9 October 2015

SCEGCS
Redlands Limited
C/- Bloompark Consulting Pty Ltd
Suite 2.02/41 McLaren St
NORTH SYDNEY NSW 2060

Urban Design Outcomes Letter – Master Plan for SCEGCS Redlands Senior School Campus at 272 Military Road, Cremorne – SSD 6454

**Drawing Title**  
ENVELOPE DIAGRAMS

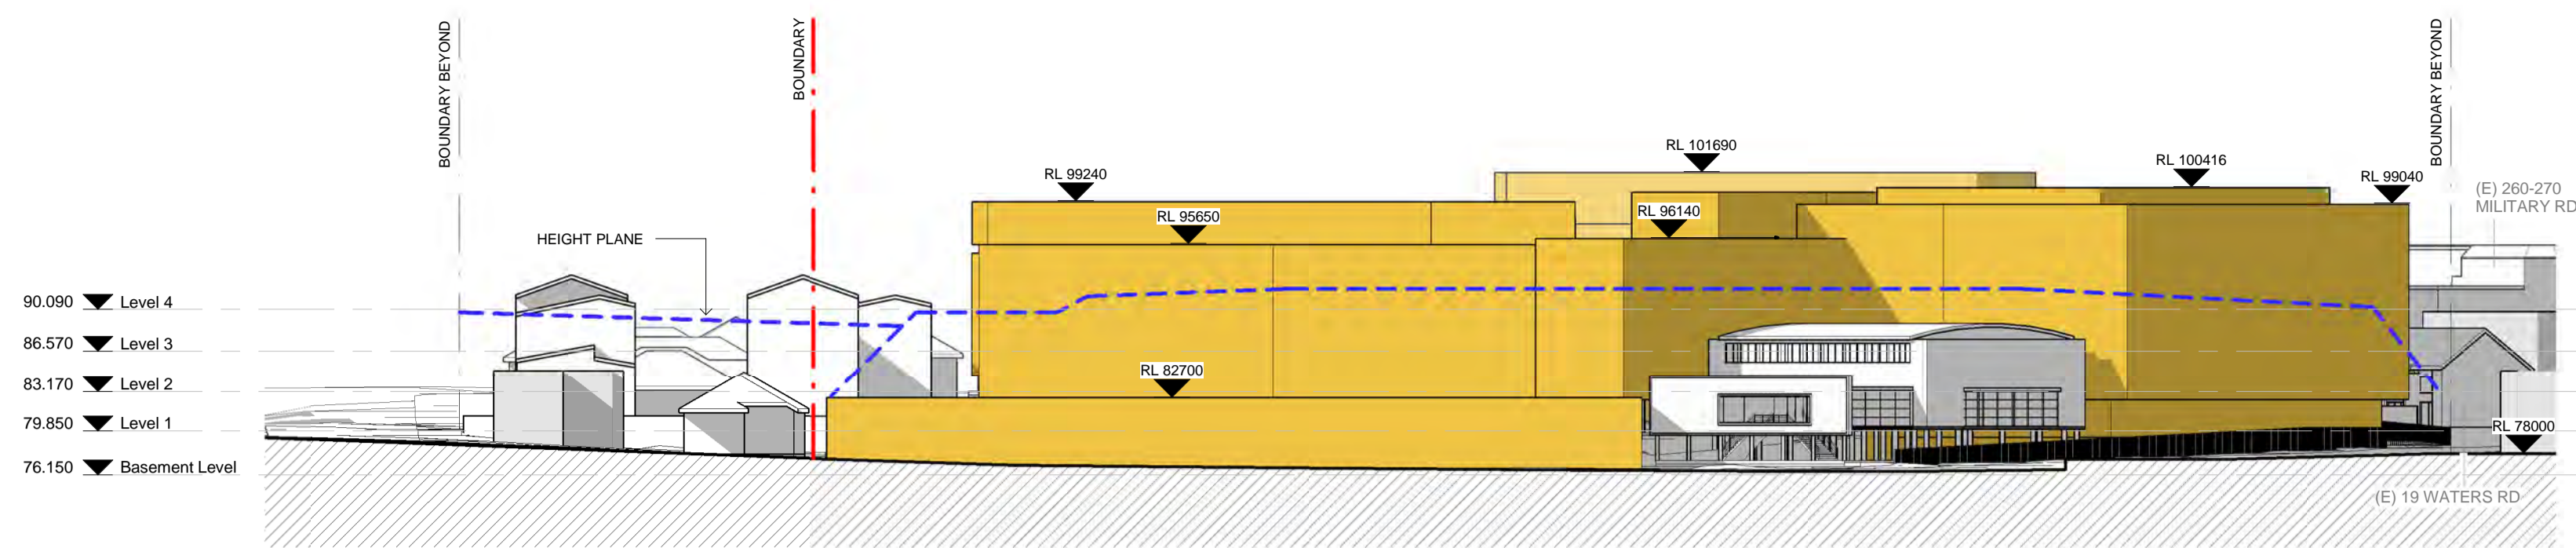
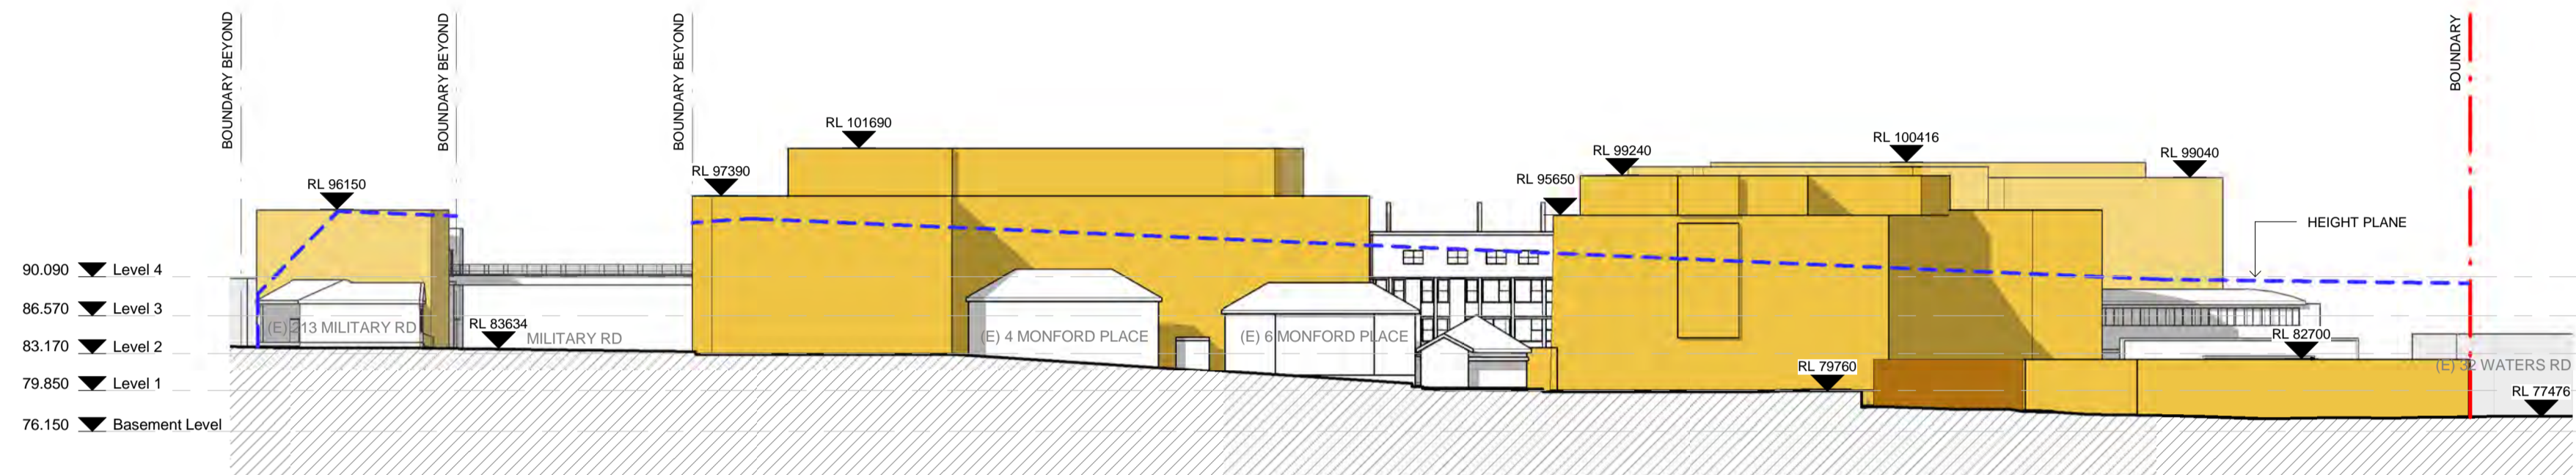
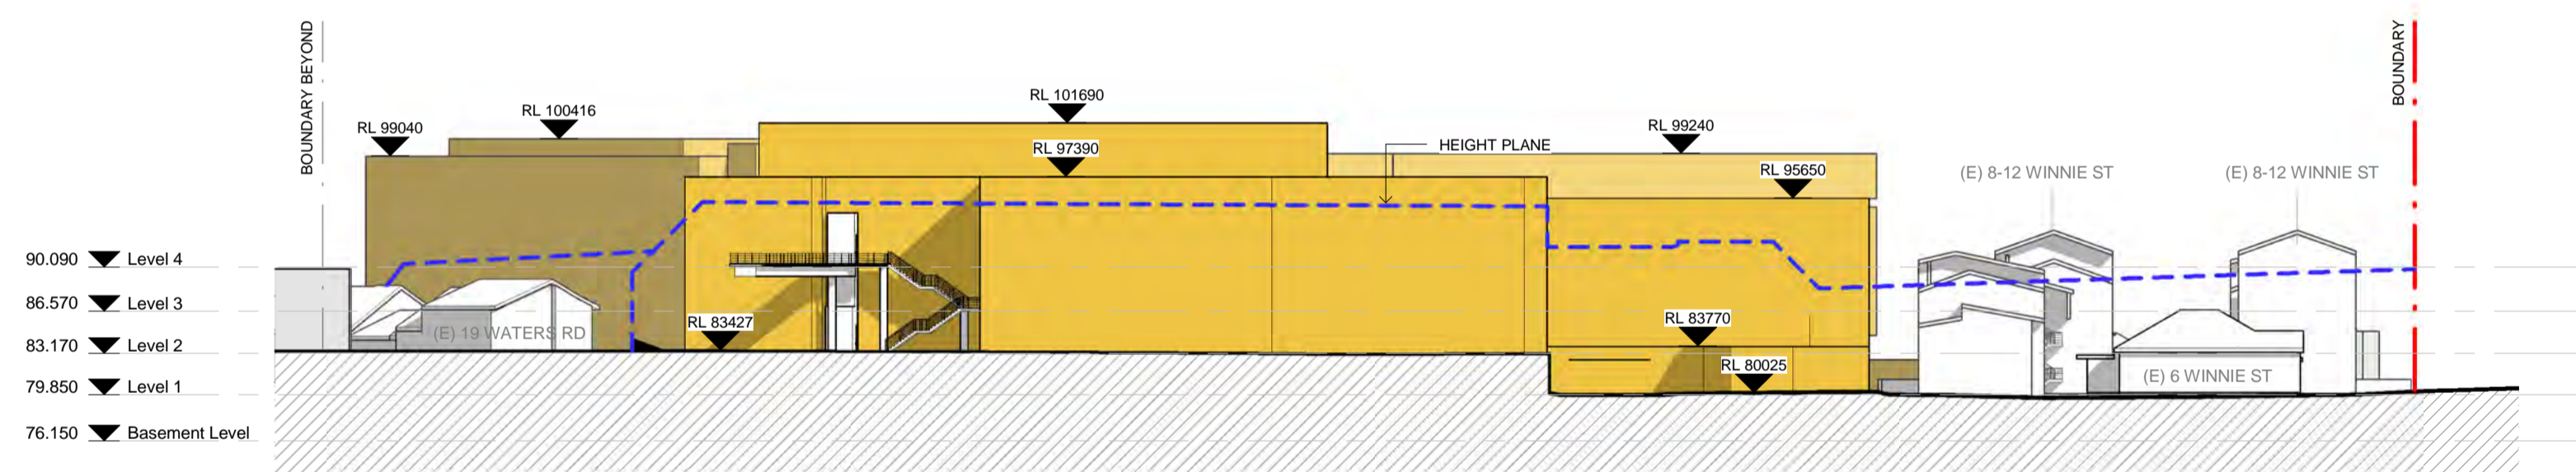
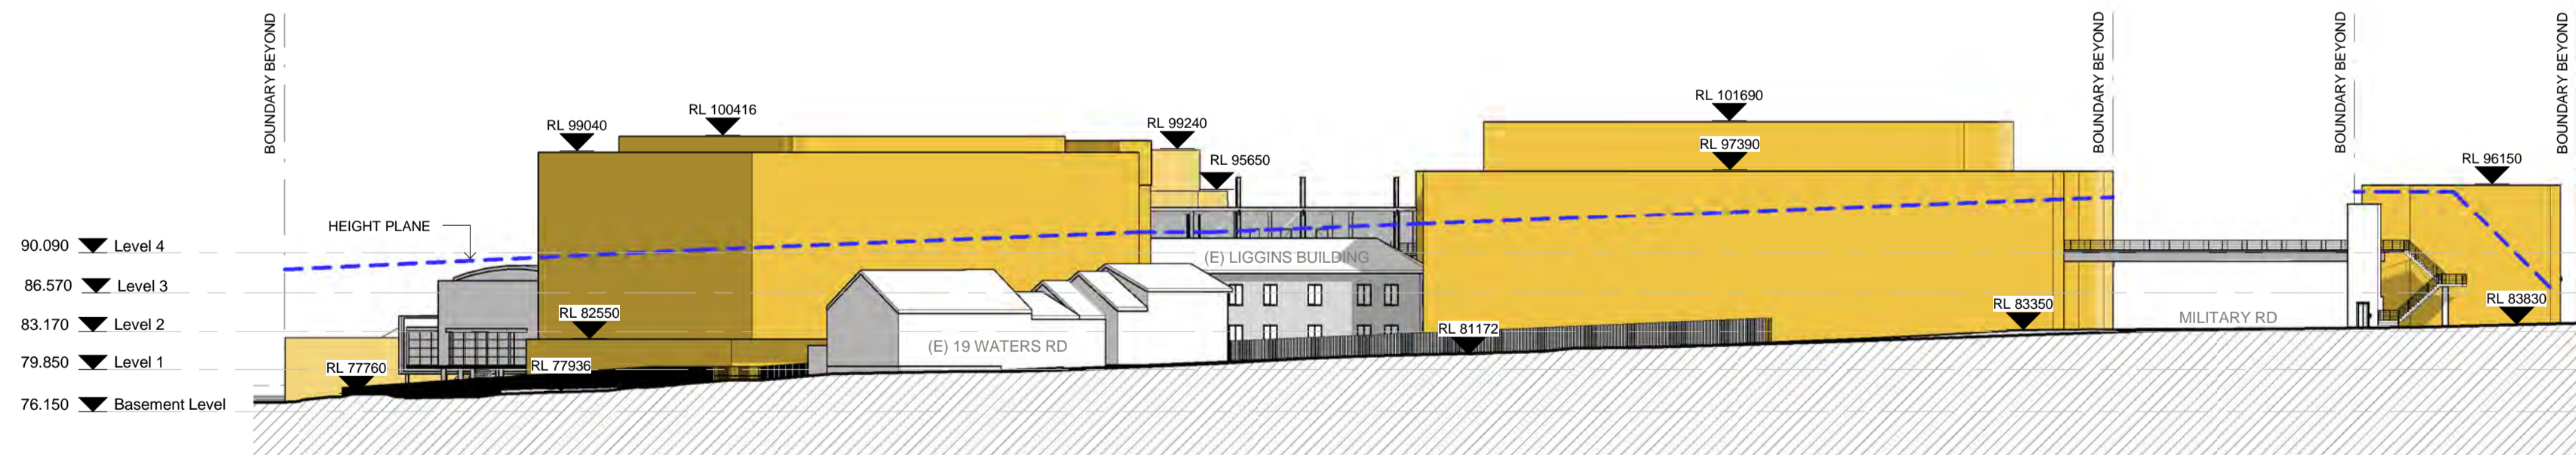
The Department of Planning identified some key issues regarding the bulk and scale of the Sports Hall/ Drama Building. In particular the Department is concerned about the potential impact that the building envelope could have on existing Monford Place residential properties and its relationship with the existing scale of Military Road built form.

North Sydney Council raises specific concerns regarding the scale of the New Sports Hall and Drama Building (Stage 2) fronting Military Road. The New Sports Hall has a maximum building height of approximately 19.9metres and is significantly higher than existing buildings on the adjoining sites B4 Mixed Use and R4 High Density Residential zones that have maximum building heights of between 12m-16m.

- Increase the setback to Monford Place. The proposed setback to Monford Place as lodged with DPE is not generally consistent with the existing character as illustrated by the blue line in Figure 1. An increased setback to Monford Place will minimise the buildings perceived bulk and scale to the streetscape. We suggest the setback for the Sports Hall be in alignment with the existing residential buildings.

- Step down the building height to Monford Place. The proposed building Place as lodged with DPE presents a large continuous building mass to Monford Place with no setback to articulate the streetwall presence of the building. Stepping down the building to Monford Place in combination with an increased setback (as recommend above) will provide an articulated streetwall presence which will make the proposed new building more compatible and sympathetic to the existing surrounding built environment.

- Increase the setback to Waters Road. The proposed setback to Waters Road Place as lodged with DPE is not generally consistent with the existing character as illustrated by the blue line in Figure 3. An increased and varied setback to Waters Road will minimise the buildings perceived bulk and scale to the streetscape. We suggest the setback for the Humphreys Learning Hub be in alignment with the Lang Gymnasium.

- Step down the building height to Waters Road. The proposed building as lodged with DPE presents a large continuous building mass to Waters Road with only a single setback to articulate the streetwall presence of the building. Stepping down the building to Waters Road in combination with an increased and varied setback (as recommend above) will provide an articulated streetwall presence which will make the proposed new building more compatible and sympathetic to the existing surrounding built environment.
